# EL PASO COUNTY PLANNING & COMMUNITY DEVELOPMENT SIGN APPLICATION

Name: DENTAGON LLC.  
Address: 1290 AINSWORTH ST.  
COLORADO SPRINGS, CO

# Application\_v1-redline.pdf Markup Summary

Vicinity Map
Tax Schedule # 5407205035
Please show major intersections.

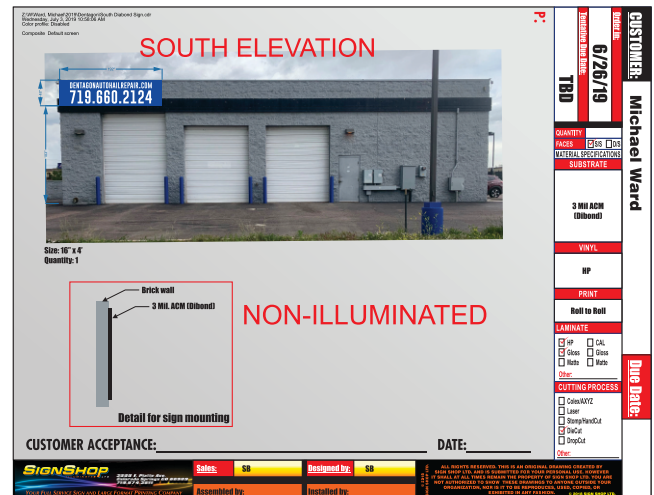
This is not the correct parcel number.

The address is also not correct.

Sign Plan
(Please indicate dimensions and sign copy)

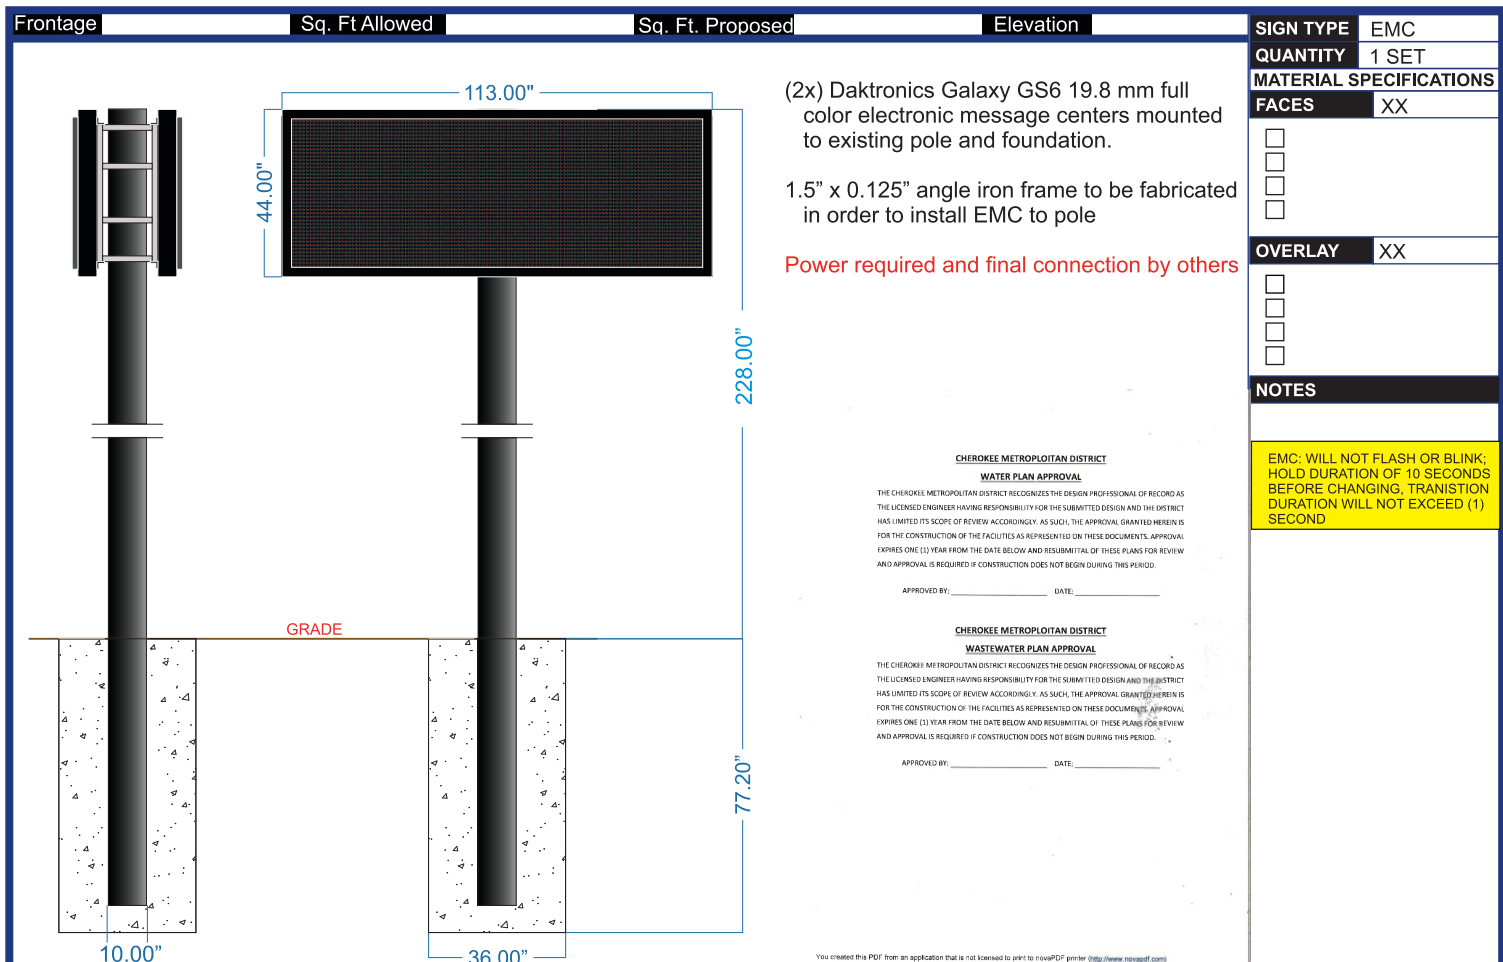
Should be shielded or cut off from light going up.

No sign is allowed with lights or illuminations that flash, move, rotate, scintillate, blink, flicker, vary in intensity, vary in color, or use intermittent electrical pulsations, except time-temperature-date signs. A change in the advertising copy or message that occurs more rapidly than once every 4 seconds will cause the sign to be considered a blinking or animated sign.

Which building elevation is this? Show it on the site plan on page 5.

No sign shall be illuminated unless the source of light is steady and suitably shielded in accordance with the lighting standards of this code.

PROJECT No.	19-0118 R1
DATE	7/25/2019
DRAWN BY	ZM
CHECKED BY	BD/LM
D-1	
Pier Detail

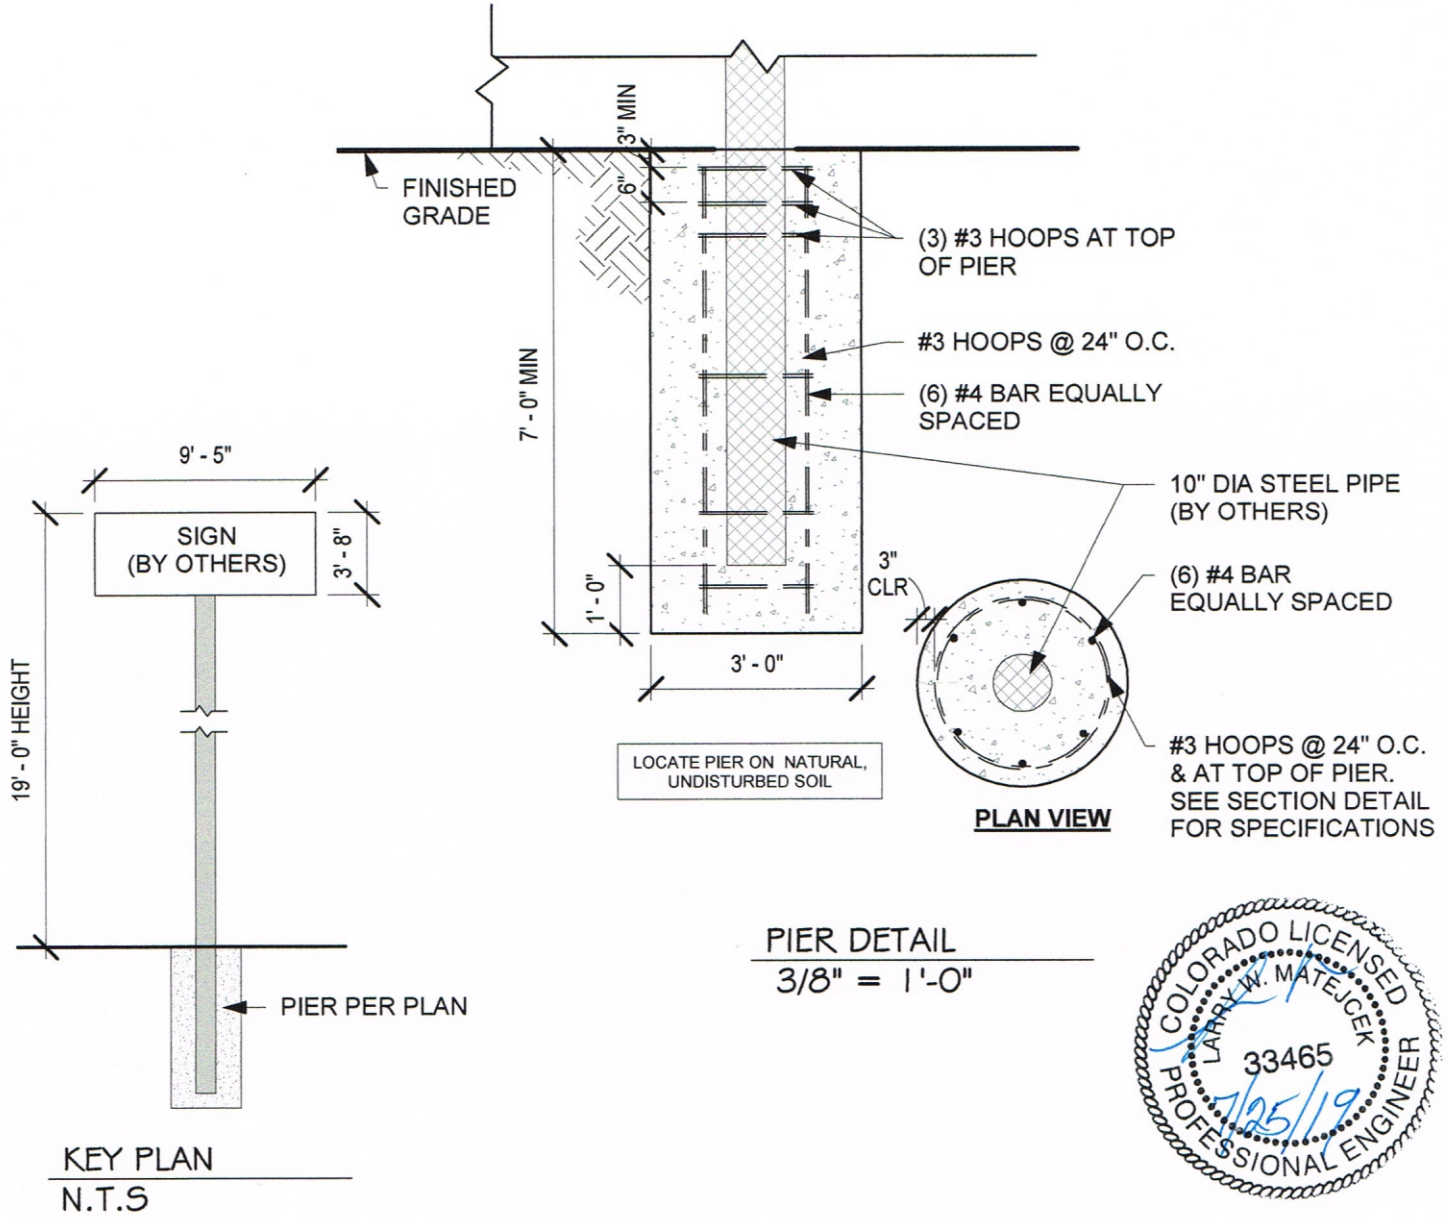
Cannot exceed the height of the building.  
19.25 feet.

These dimensions are different than the other pages of this application.

FIGURE 0811C

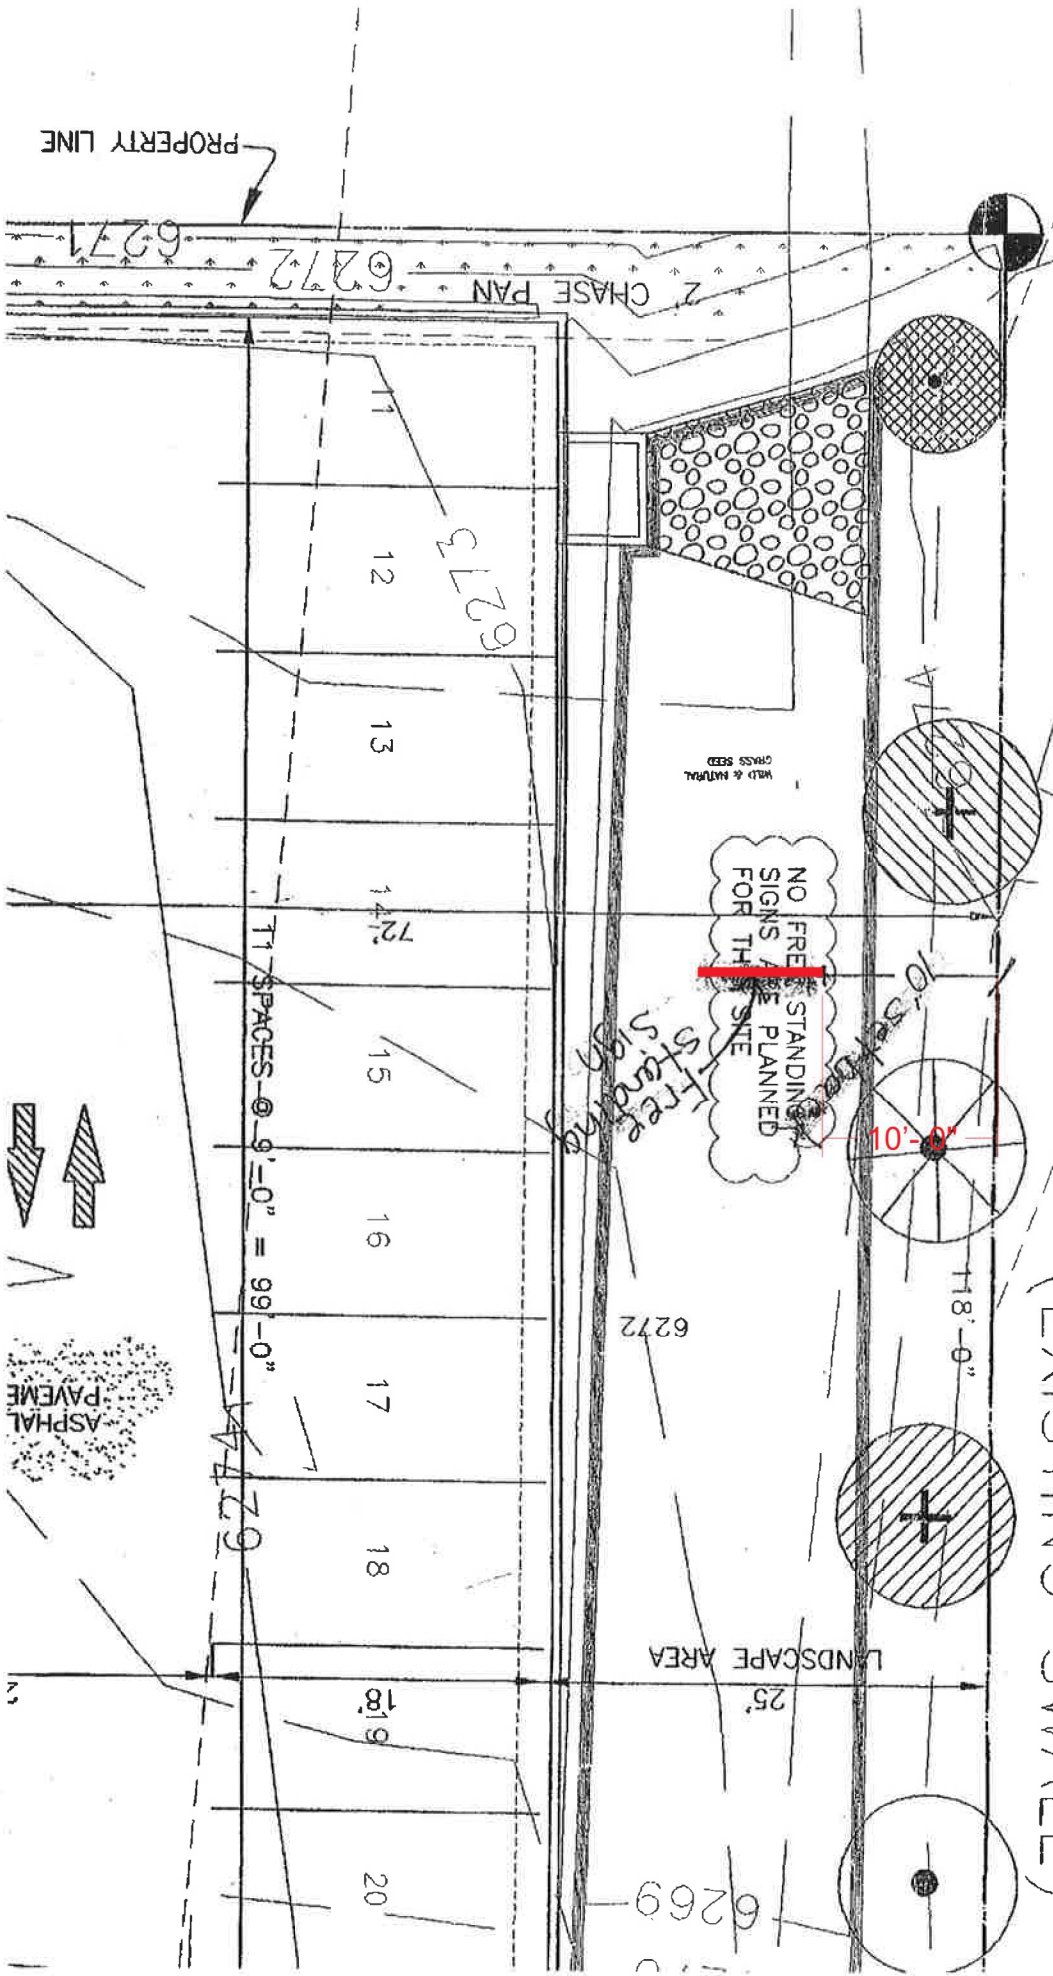
No sign shall be placed in a drainage or utility easement.

This needs to show the entire site. A sign cannot be within a d
